**WELWYN HATFIELD BOROUGH COUNCIL  
EXECUTIVE DIRECTOR - PLANNING, PUBLIC PROTECTION AND GOVERNANCE**

**DELEGATED APPLICATION**

**Application No:** 6/2017/2329/FULL  
**Location:** Land Adjacent to 37 Lambs Close Cuffley EN6 4HD  
**Proposal:** Erection of 3 x 2-bedroom dwellings with associated parking - retrospective  
**Officer:** Mr William Myers

**Recommendation:** Refused

5 Proposed Site Plan - Roof Plan  
1:200

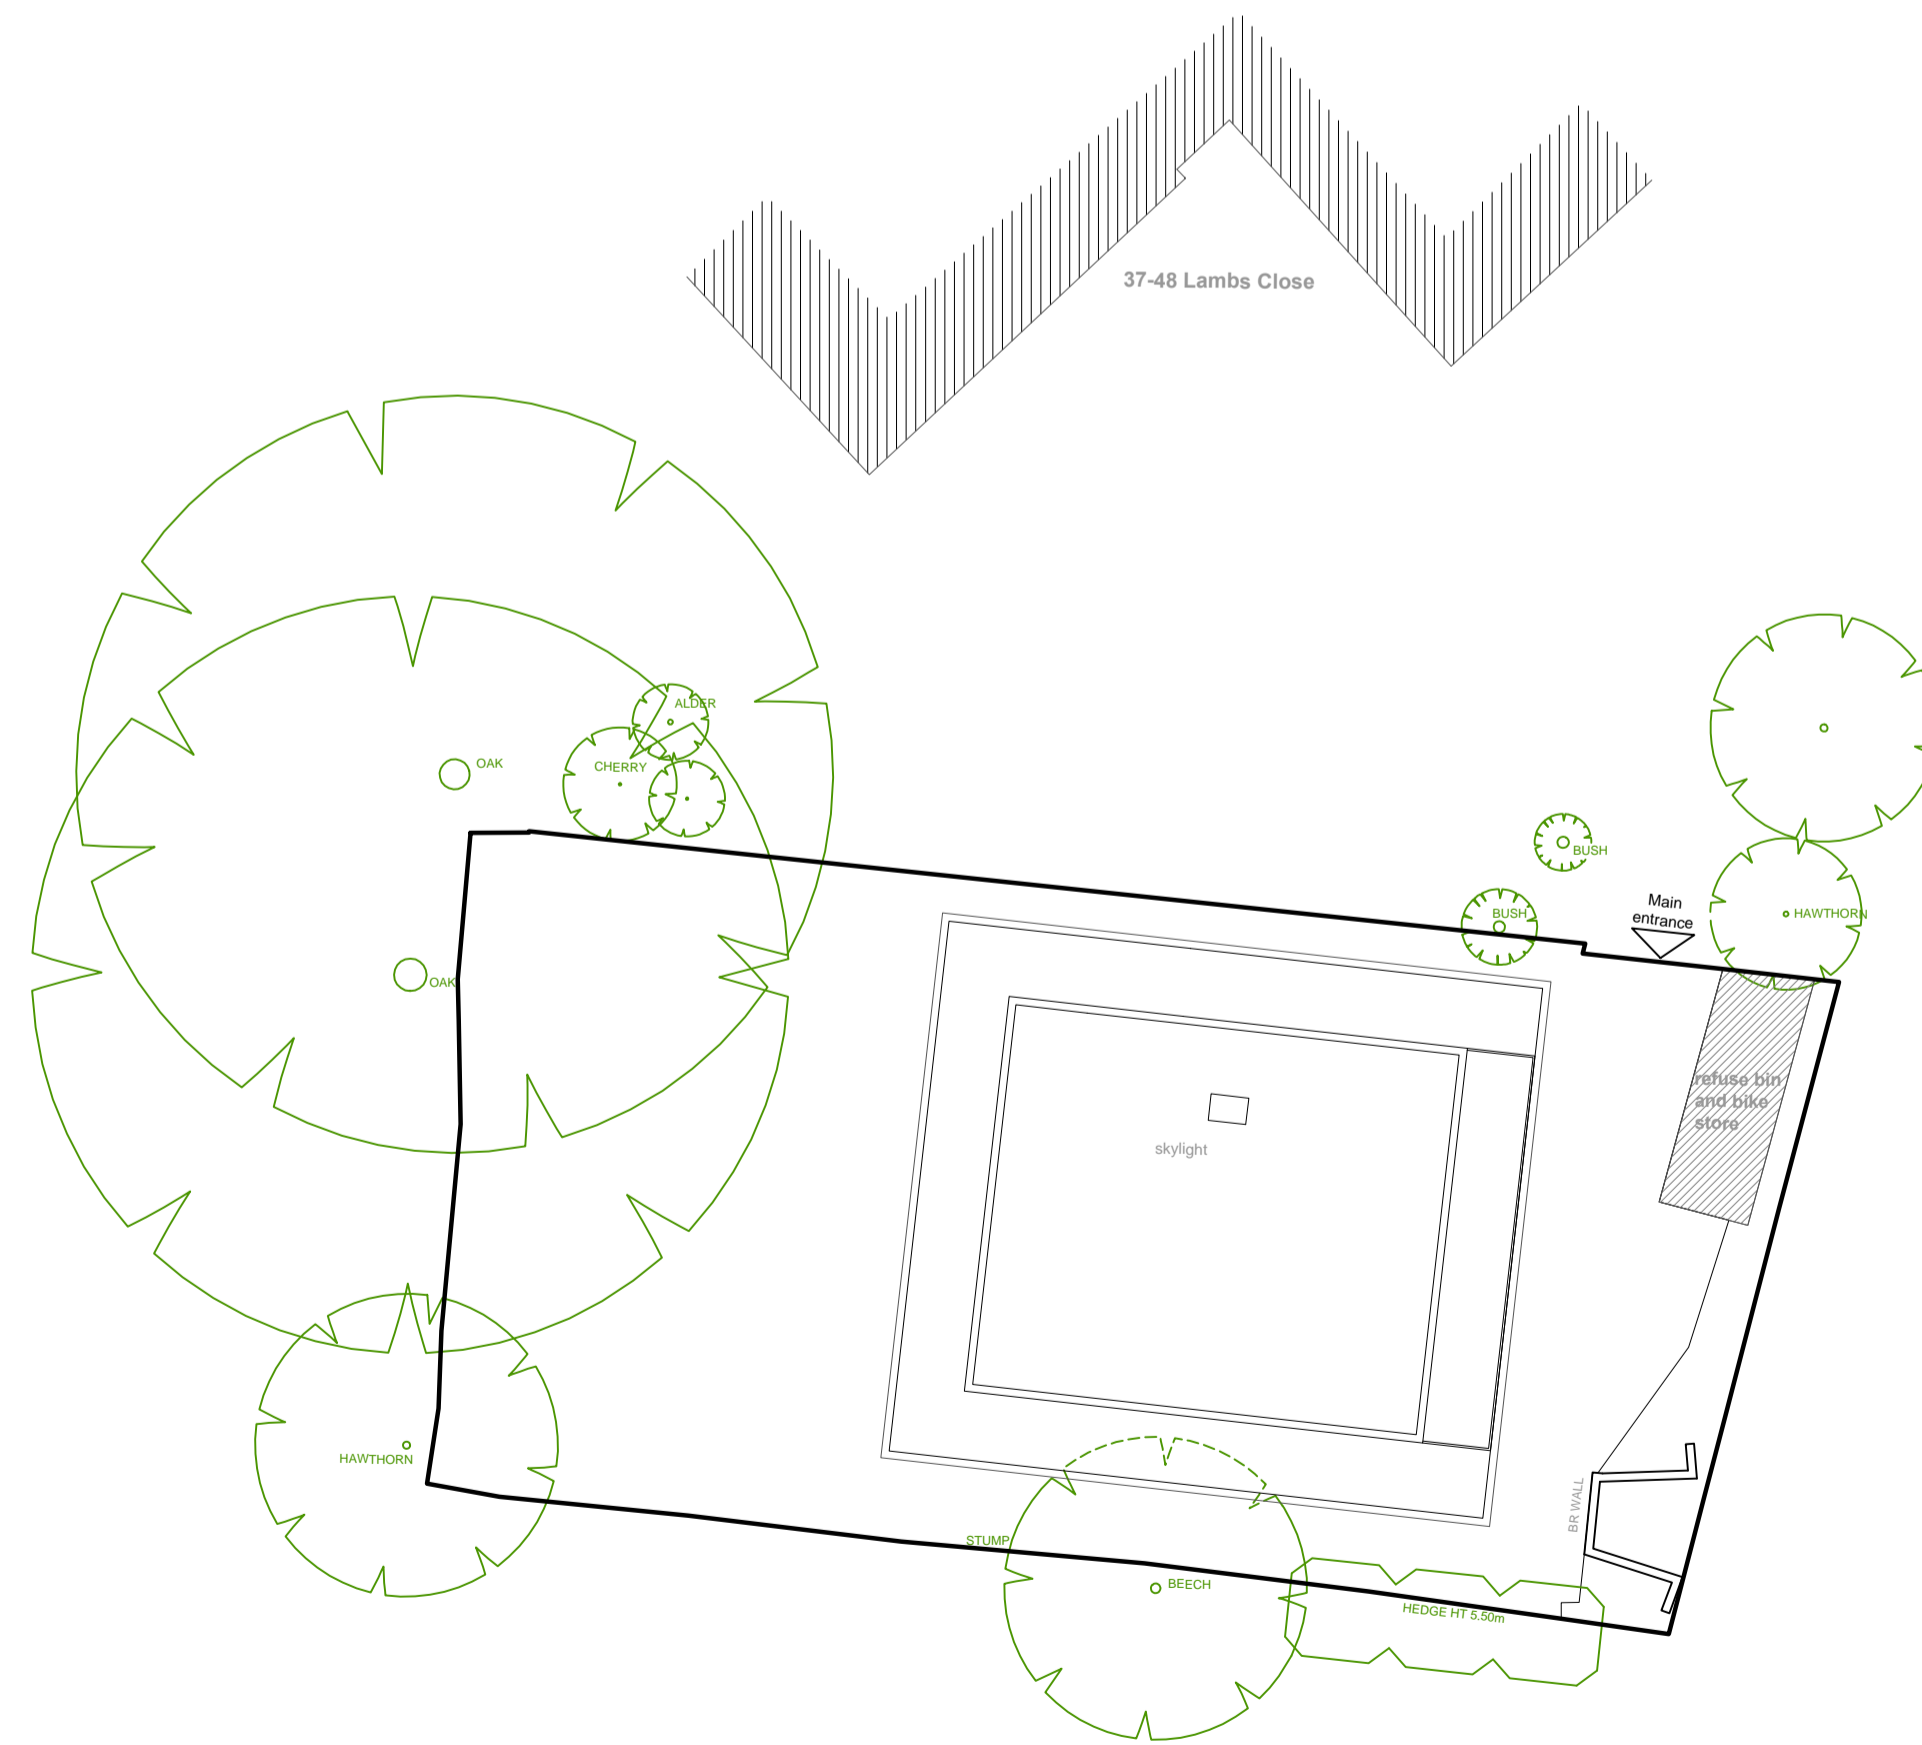
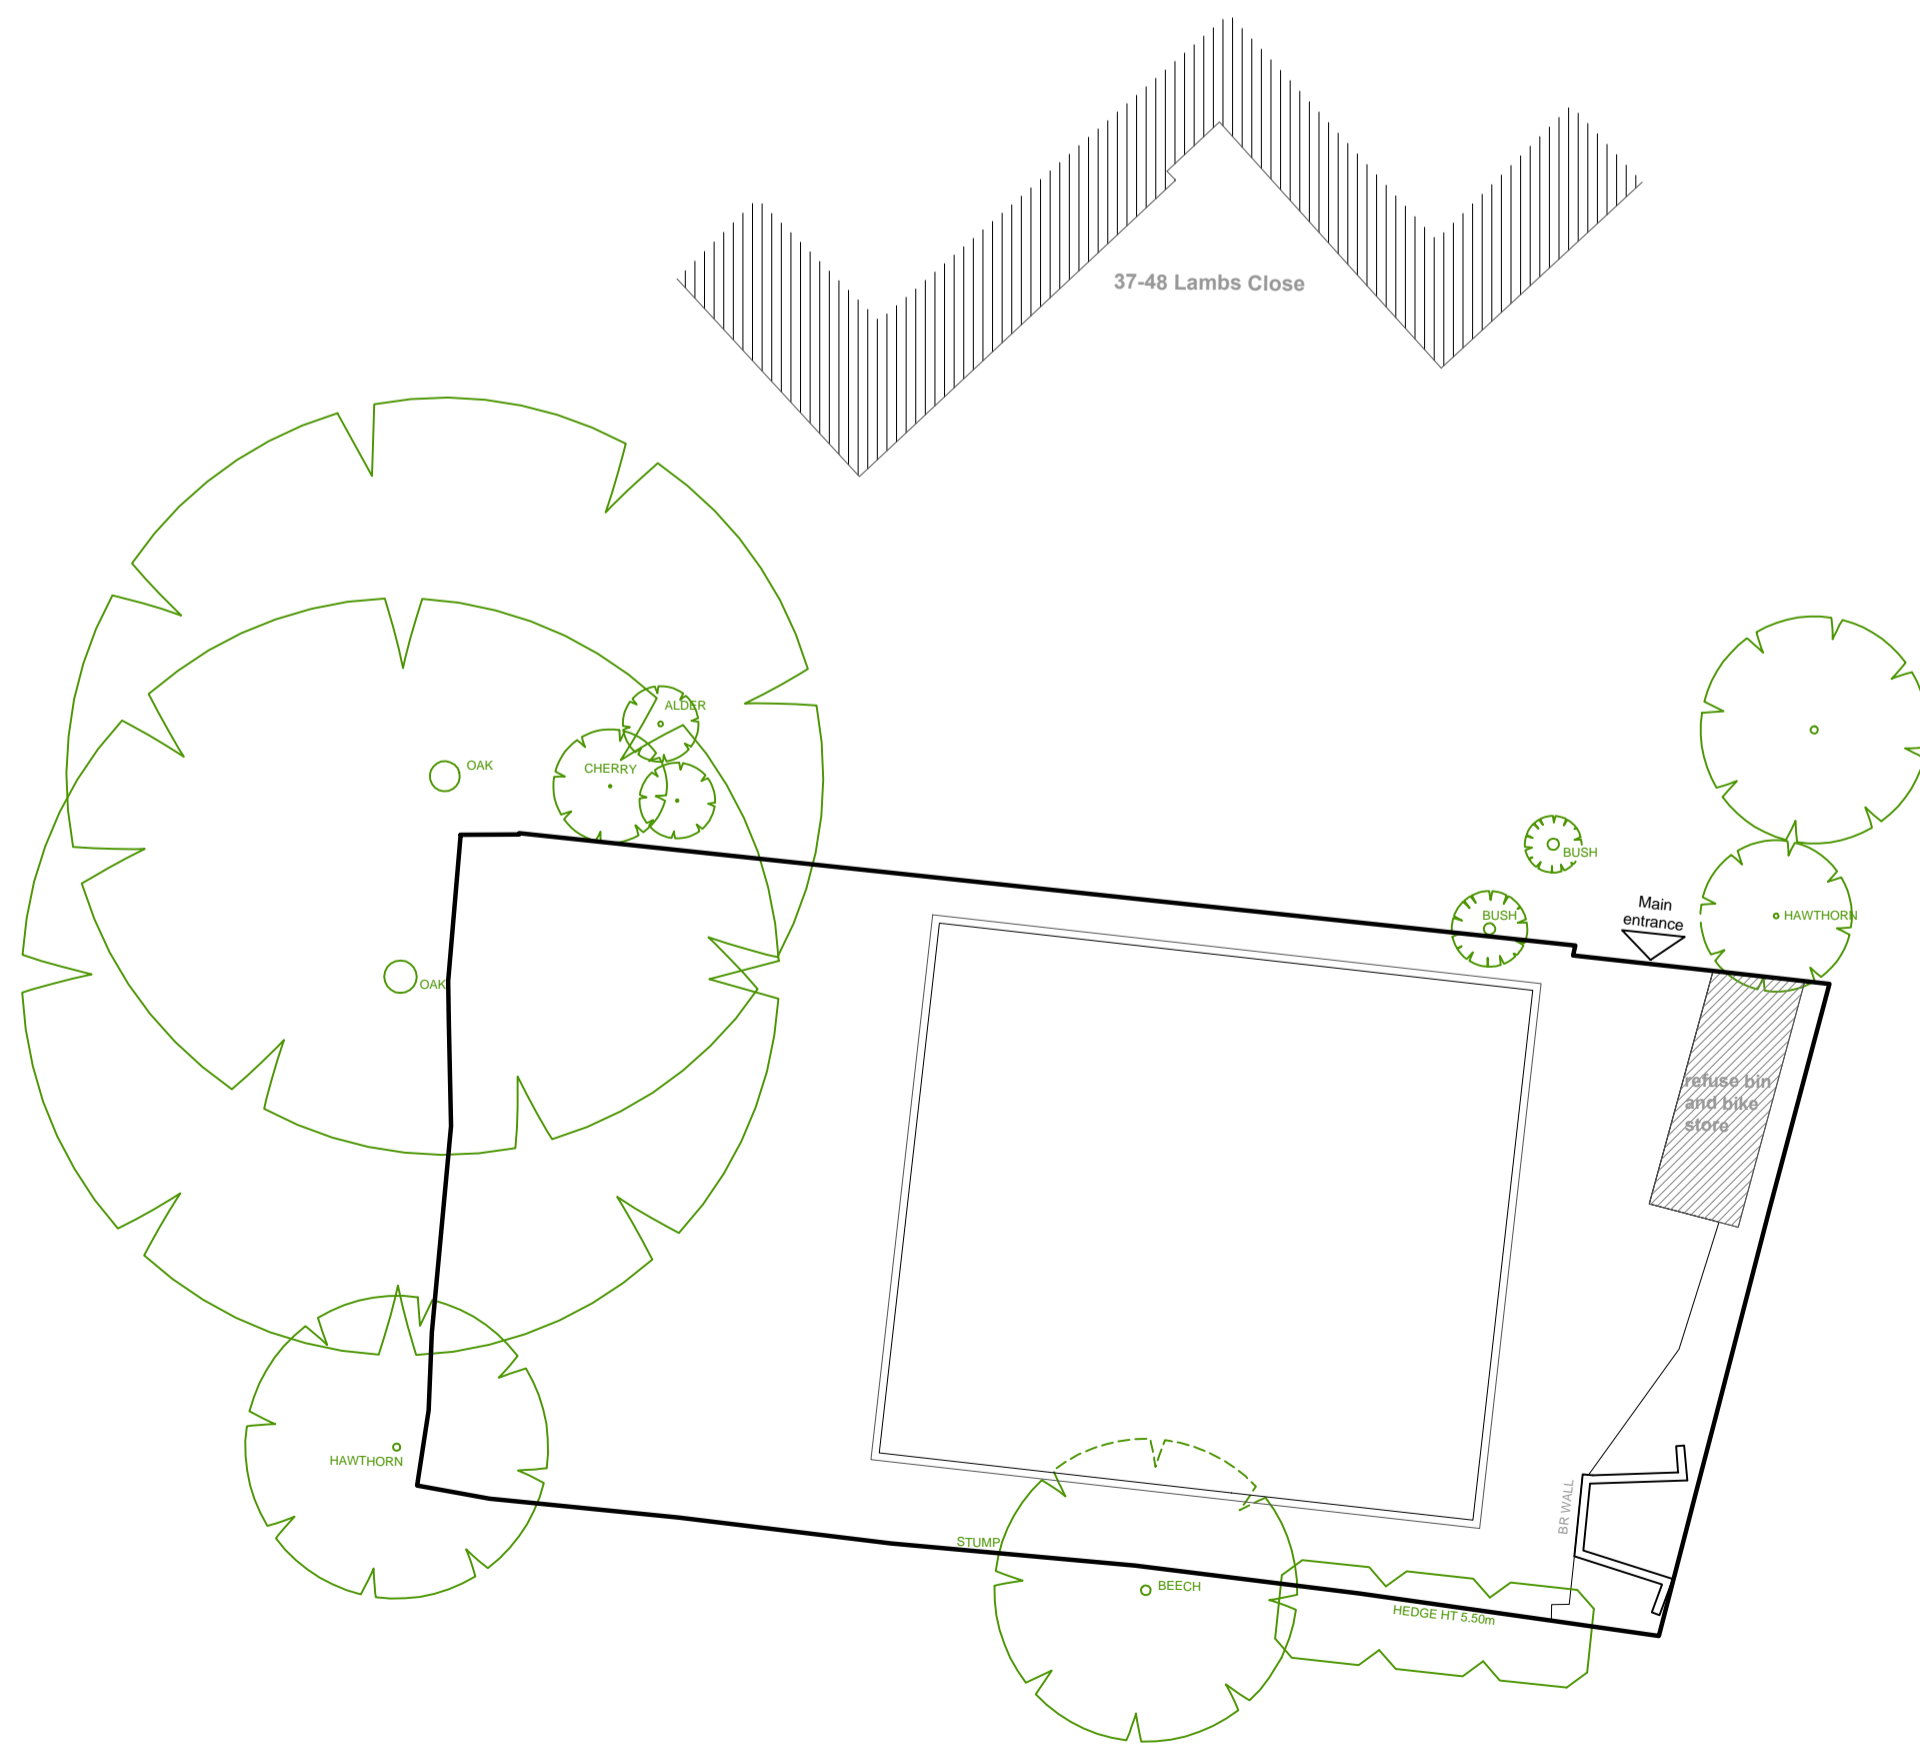
<p>The cladding of the proposed second floor addition and the use of floor to ceiling windows in this addition would be out of character with the immediate area and are inappropriate features. In addition, it is considered that the proposed additions would fundamentally change the character of the area because the new building would cease to be ancillary in terms of its size and scale to the flats within Lambs Close. Accordingly, the proposed development would be contrary to Policy D1</p>

The proposed development would result in a loss of sunlight to the ground floor windows within the southern elevation of Block D, Lambs Close resulting in unacceptable harm to the amenity and living conditions of occupiers. This is because the proposed development would block most of the direct sunlight that these flats currently receive for at least three months, over the winter, each year. Accordingly, the proposed development would be contrary to Policy D1 of the Welwyn Hatfield District Plan 2005, Supplementary Design Guidance 2005 (Statement of Council Policy 2005) and relevant provisions of the National Planning Policy Framework 2012.

The provision of 4 off-street car parking spaces would be inadequate for the proposed three, two bedroom flats, and given the clear demonstrable lack of existing car parking provision for the Lambs Close Development, it is not considered that the shortfall of off-street parking serving the proposed development would be acceptability offset via off-street and on-street parking elsewhere within the immediate vicinity. As such, the proposal development is contrary to Policy M14 of the Welwyn Hatfield District Plan 2005, Supplementary Planning Guidance 2004 (Statement of Council Policy), Interim Policy for Car Parking Standards and Garage Sized 2014 (Statement of Council Policy) and National Planning Policy Framework 2012.
